Erection of four terraced residential dwellings, garden/cycle storage sheds & associated car parking, utilising the existing access - This application may affect the character & appearance of The Steyne, Bognor Conservation Area & will affect the setting of a Listed Building

Former hotel tennis courts adj to The Royal Norfolk Hotel West Street Bognor Regis

I object to the planning application Ref No; BR/214/18/PL on the following grounds:

Drg No: **RNHB.PLAN 5**

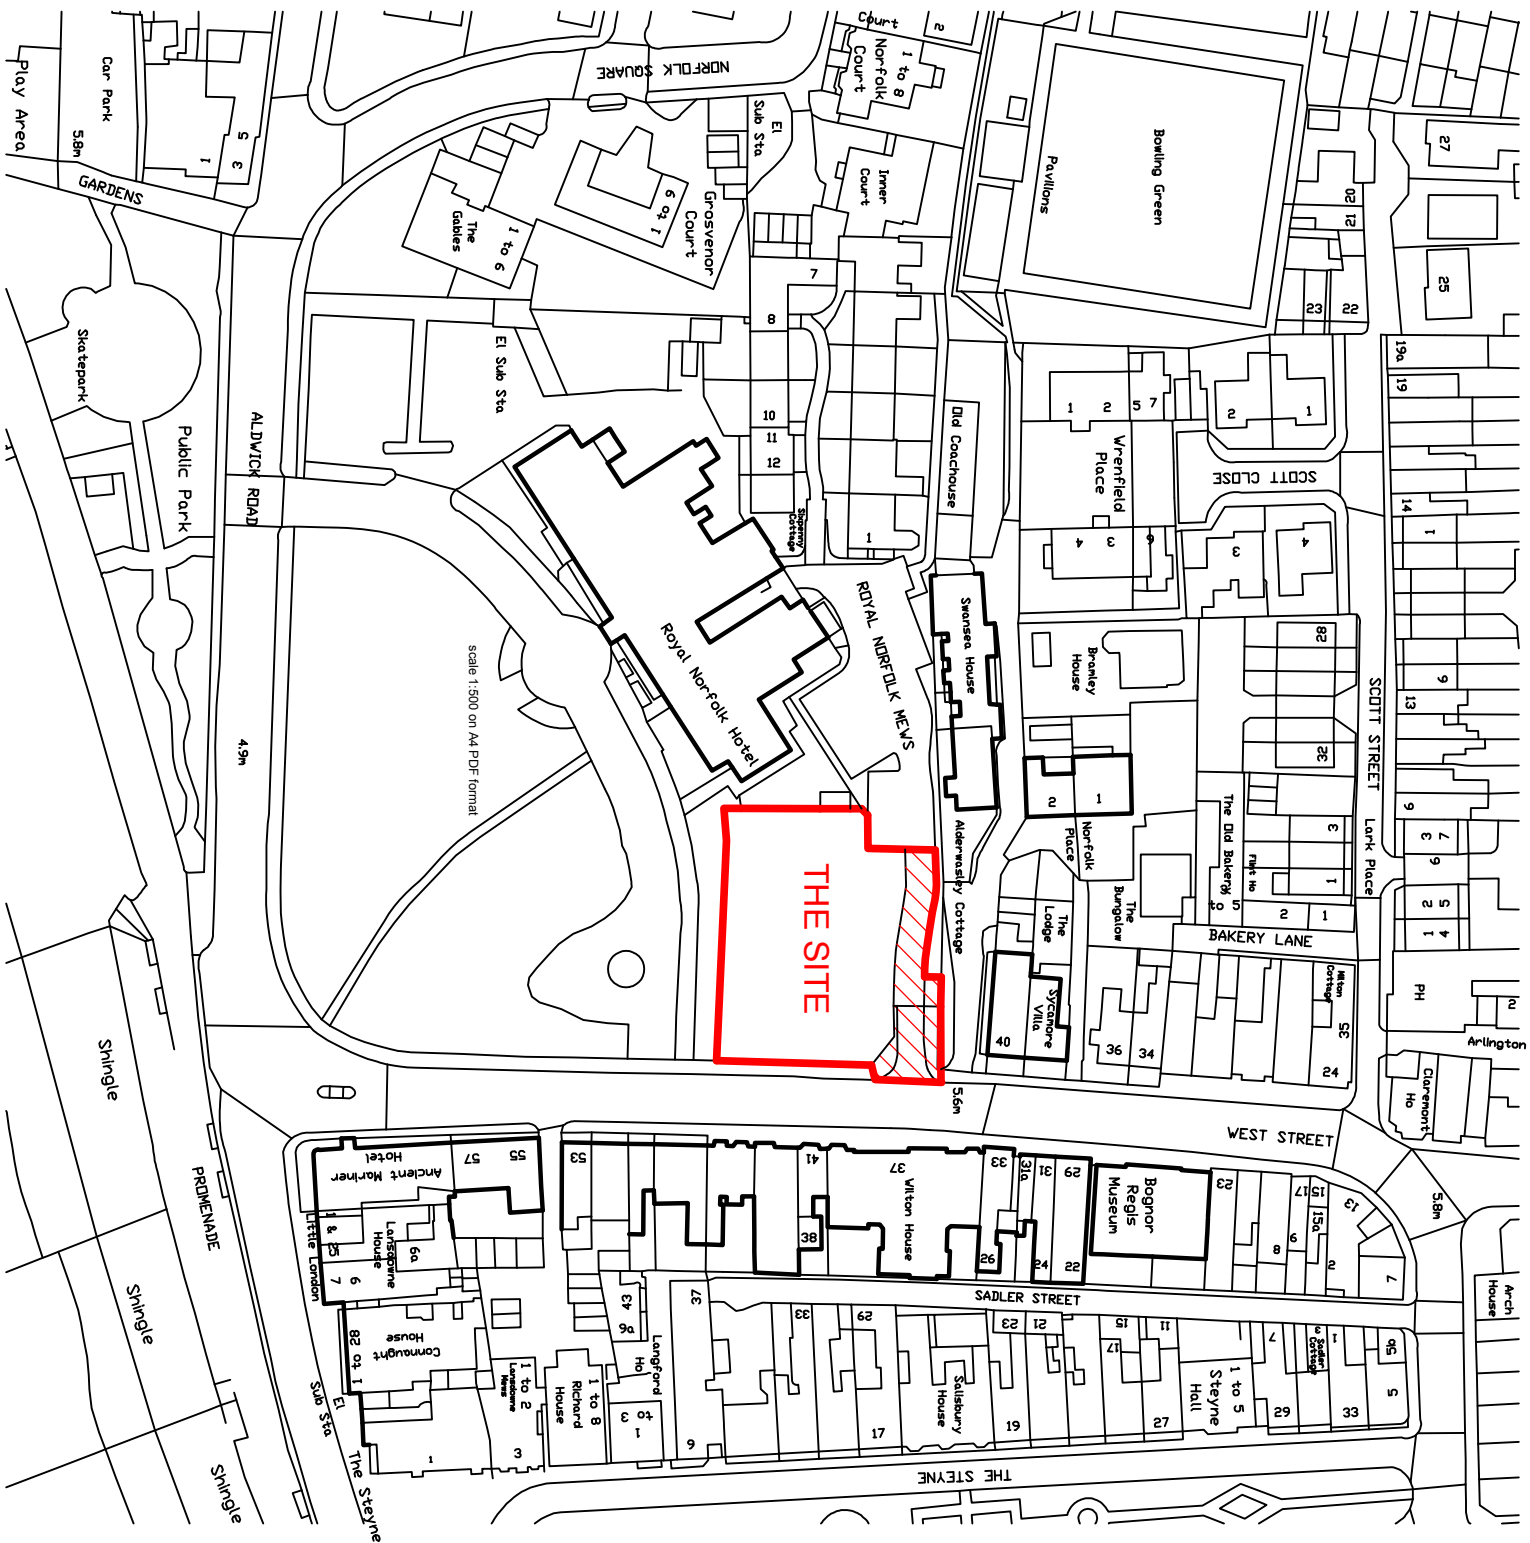
However, the new plans deposited with Arun District Council ignore this agreed positioning and place the entrance at the western end of the development to the detriment of the visitor parking owned by RNMM Ltd.

It is also unsafe for vehicles entering & exiting.

This is unacceptable and the plan should be adjusted to reinstate the previously agreed entrance.
